ABP-320705-24 (Knockshanvo Wind Farm & 110kV Substation)

VA03.320727 / ABP-317763 (110kV Grid Connection & Subsurface Cabling)

Date: 4th August 2026

We are writing to submit a formal observation directly responding to the planning statements and response to observations submitted by the applicant, FuturEnergy Knockshanvo DAC (prepared by MKO).

Section Through Permanent Reinstatement of Longitudinal Opening in Roadway  
SCALE 1:10

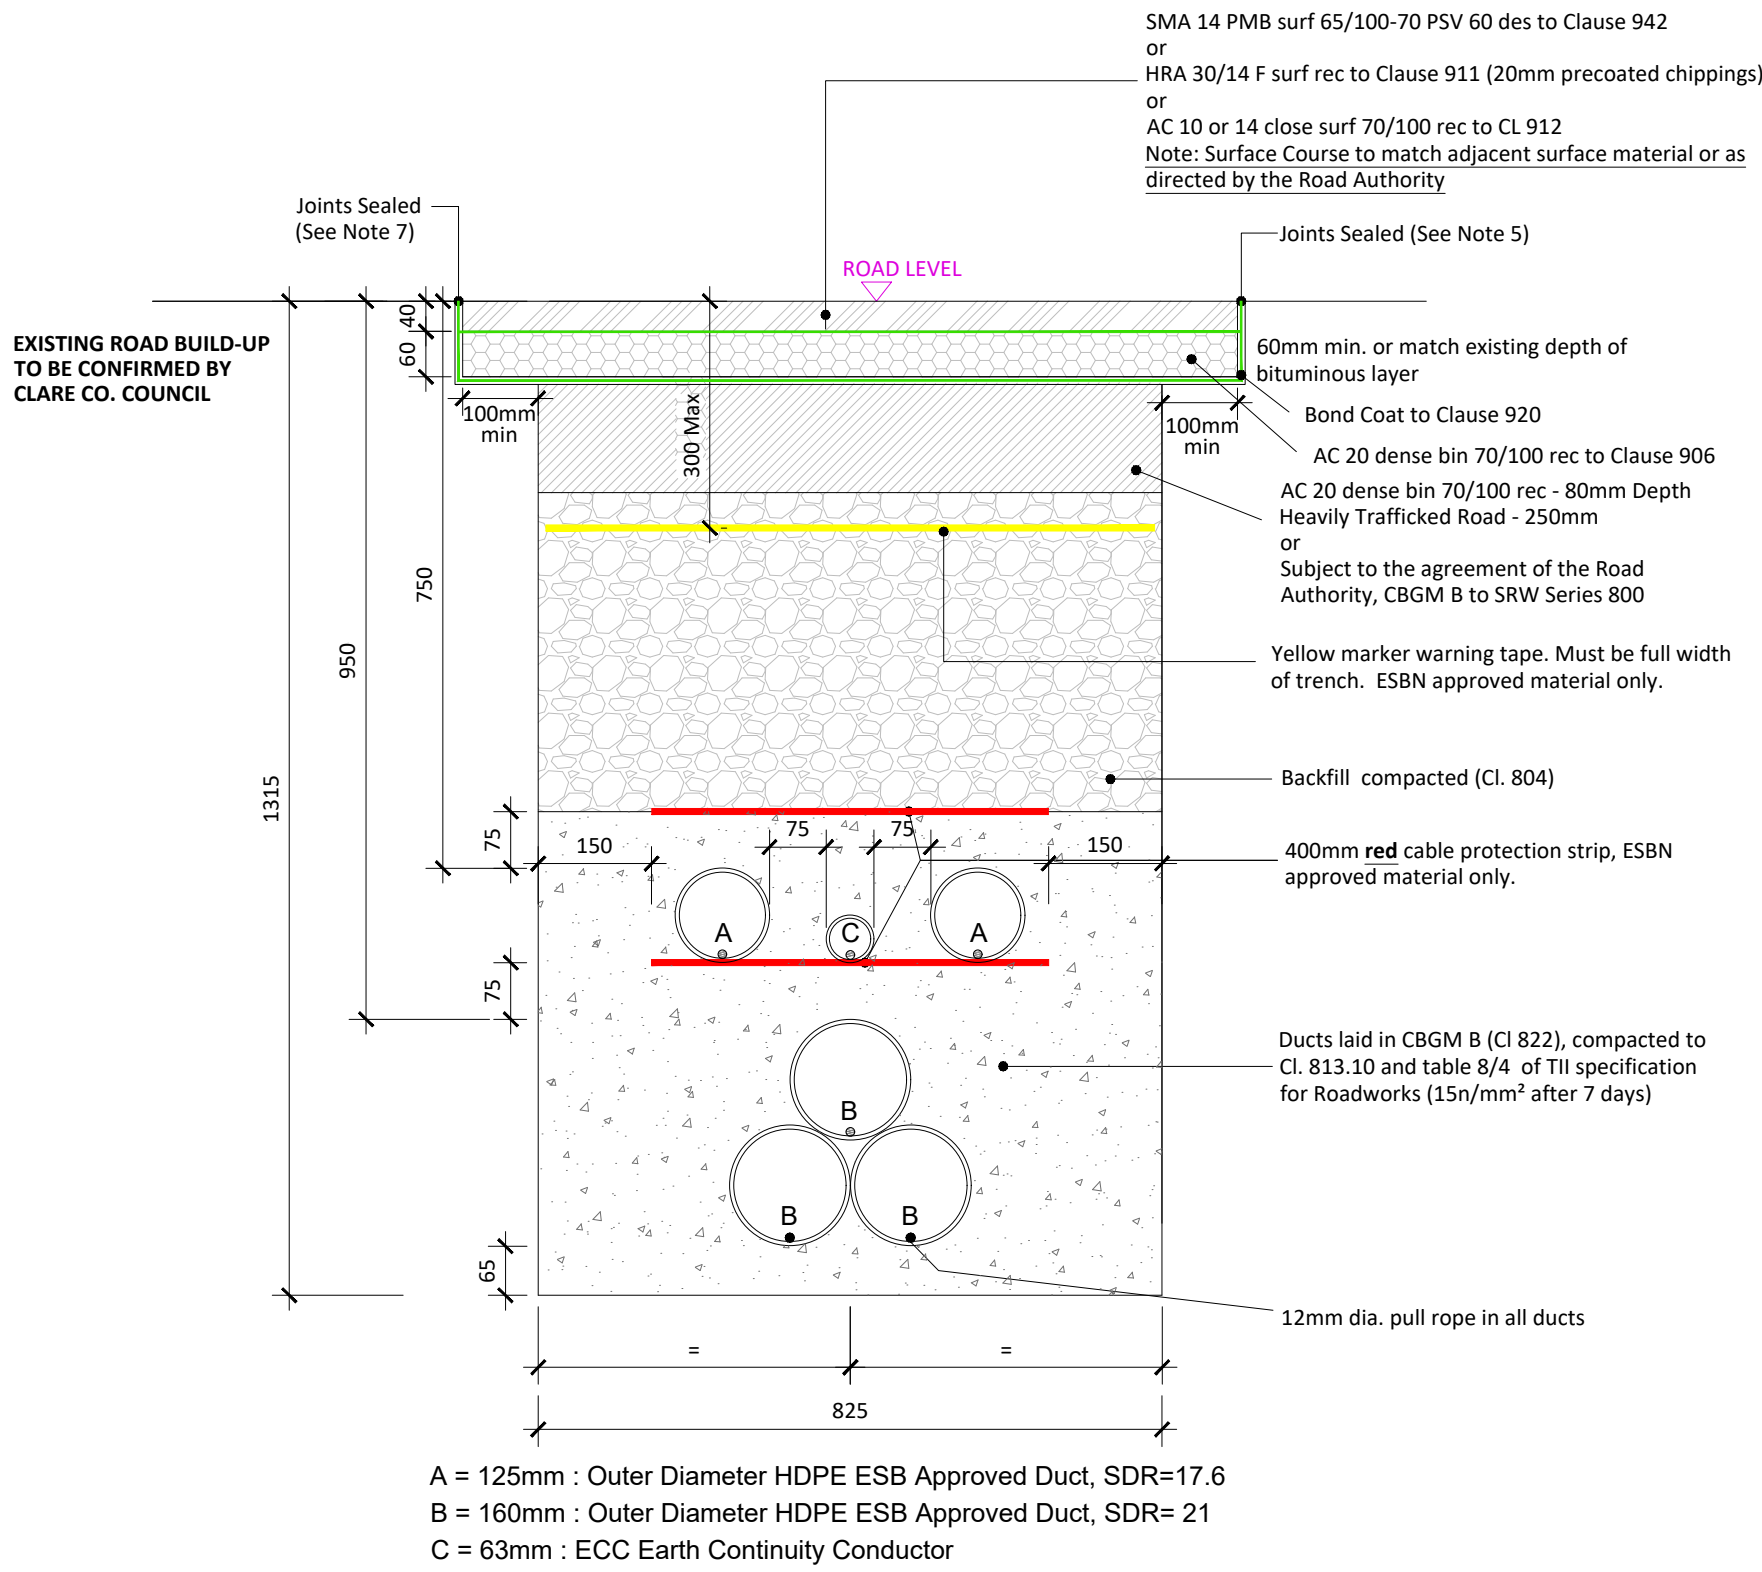
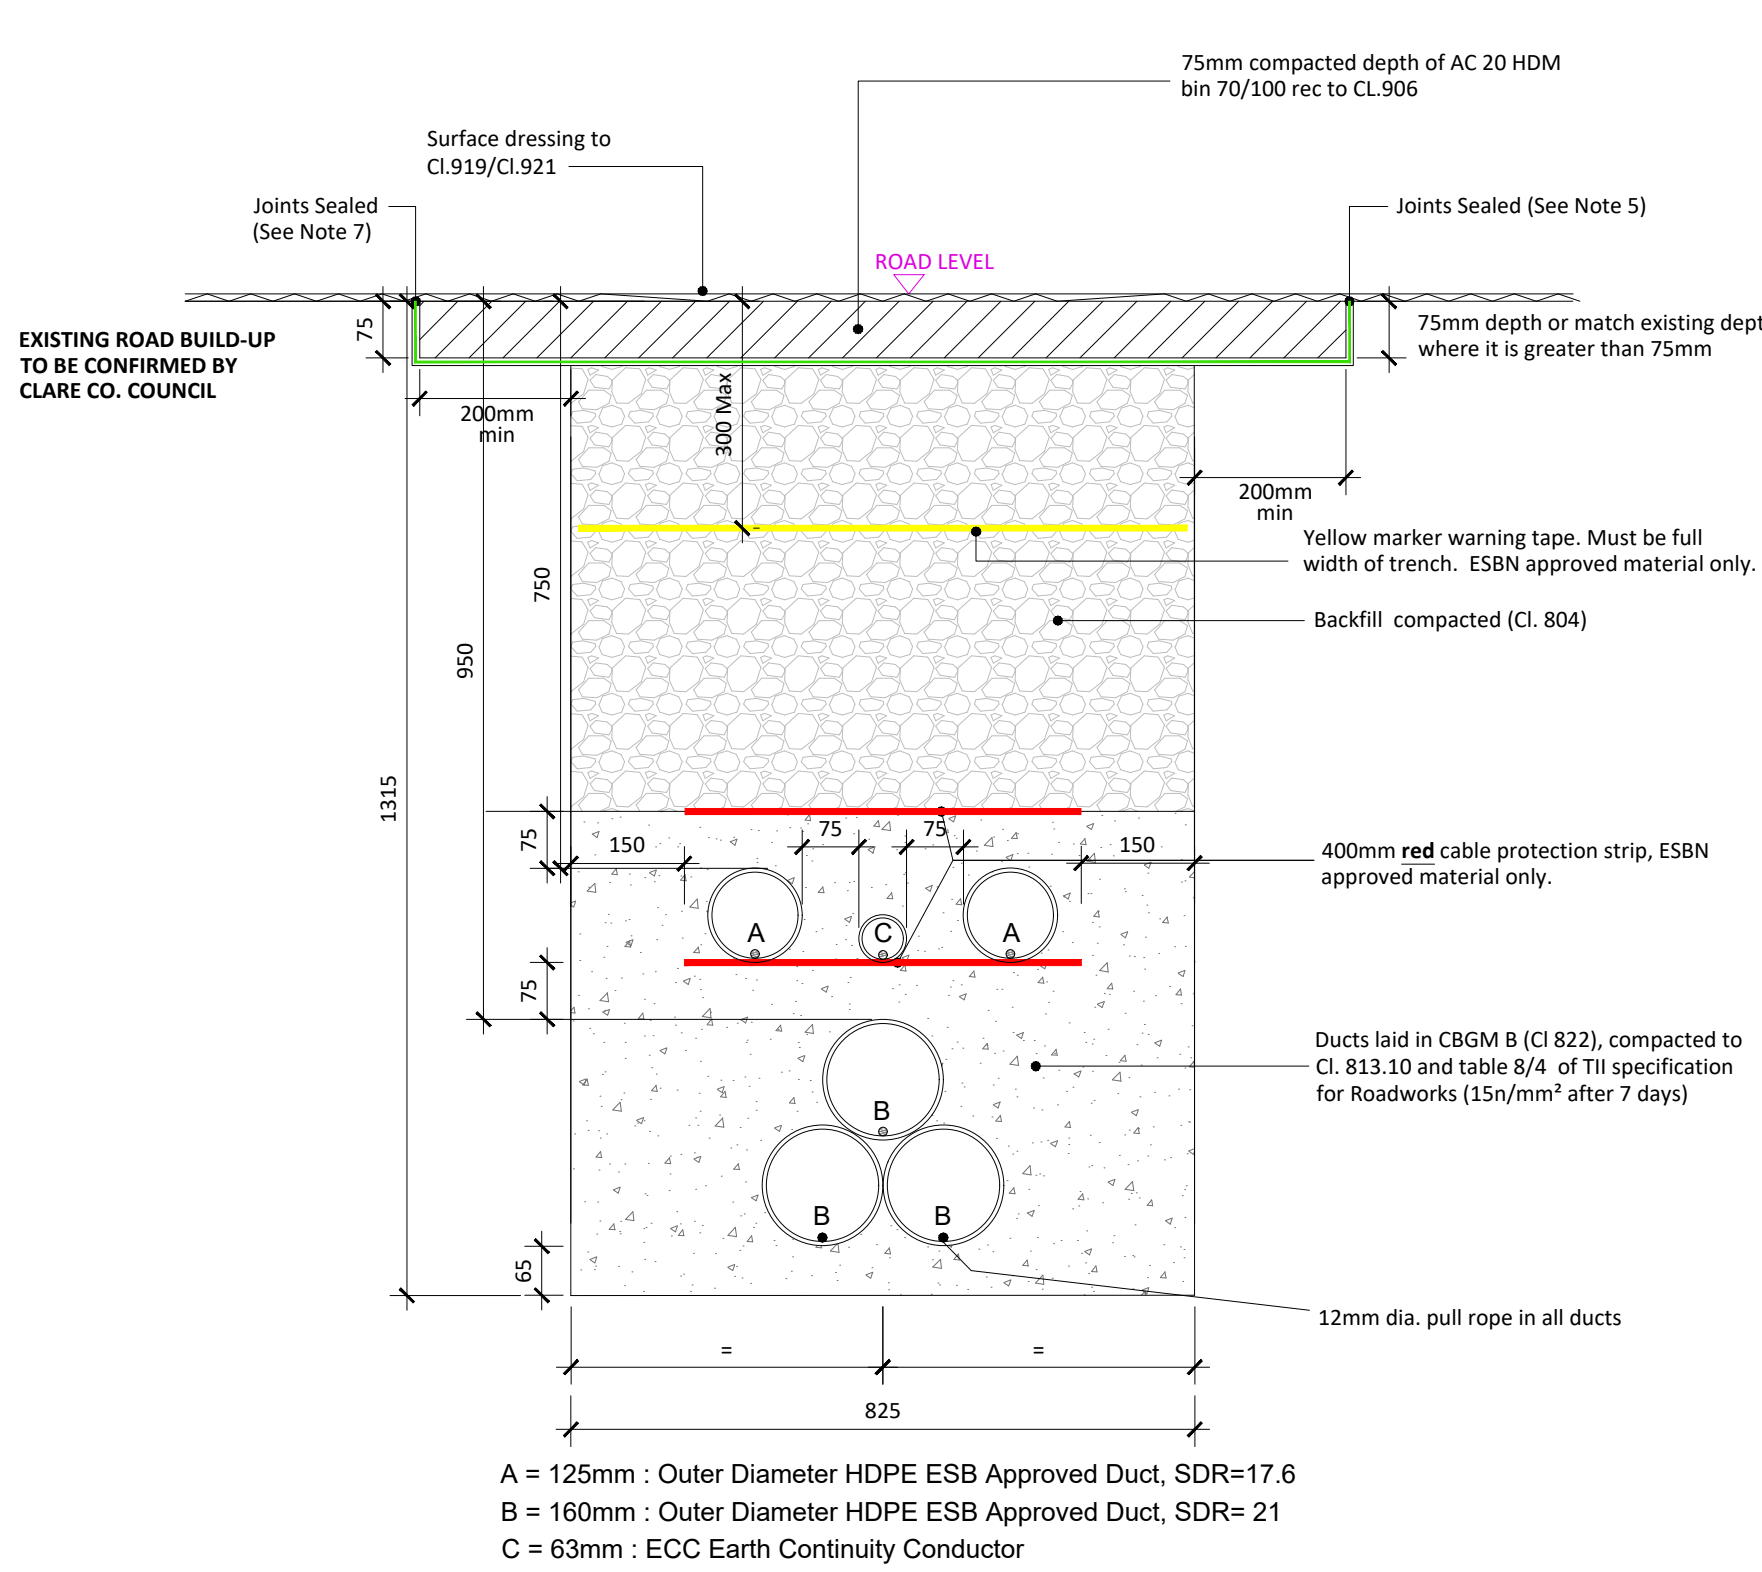
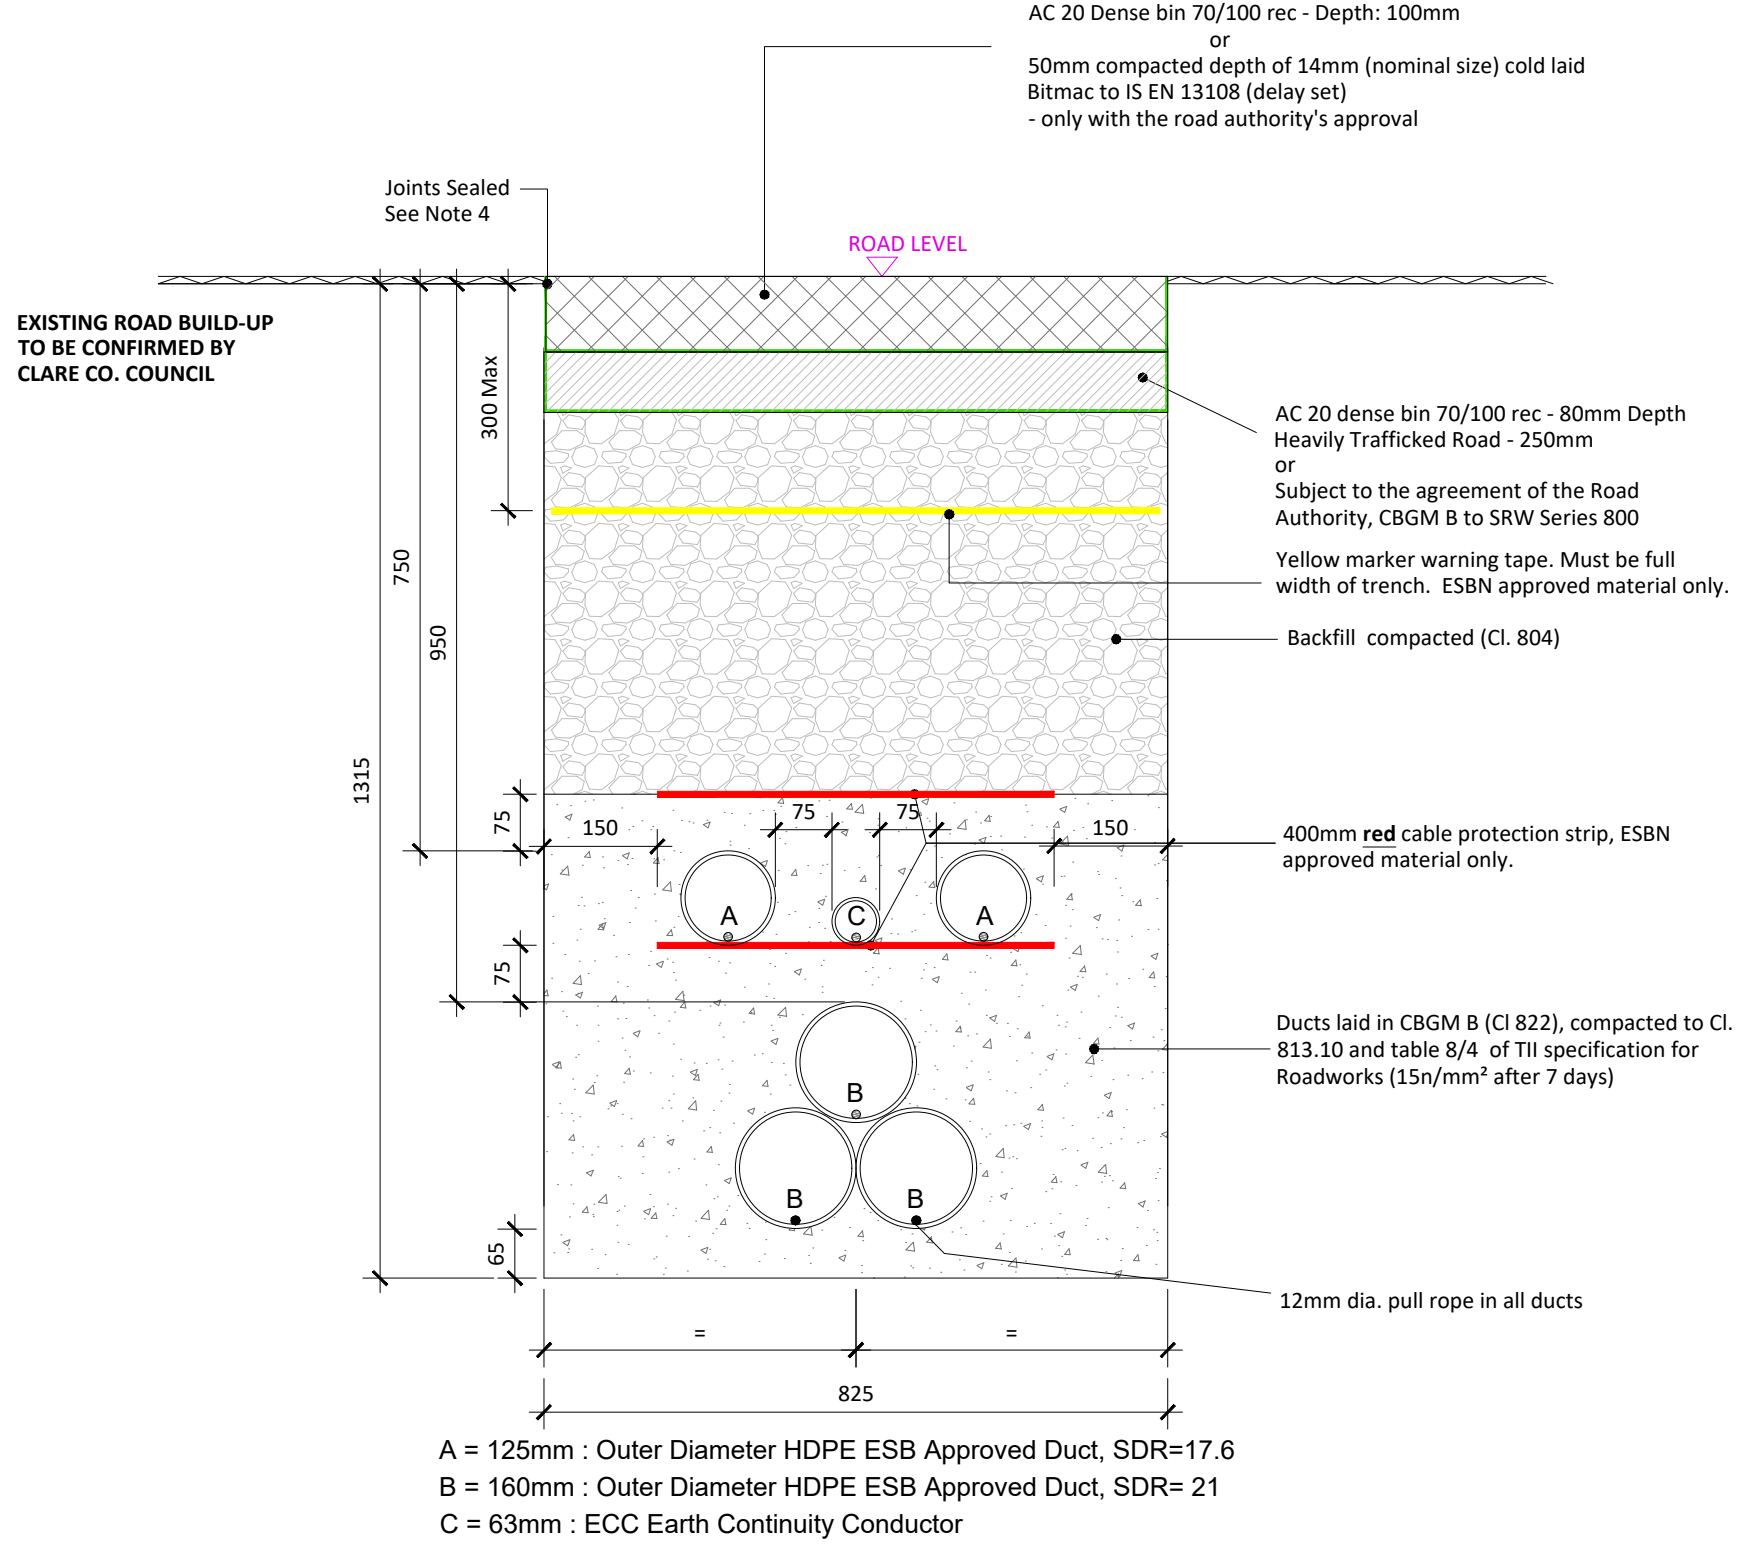
The Applicant's Position: The developer asserts that grid connection cable trenching along Sallybank Road (L3042) will cause only "temporary and short-term" construction disruptions, committing solely to standard pre- and post-construction road surface surveys for the local authority.

While MKO promises to restore the public road tarmac for Clare County Council, they have provided zero localized structural engineering assessments, zero baseline structural surveys, no vibration monitoring protocols, and no structural indemnity framework to protect our home against catastrophic cracking or subsidence.
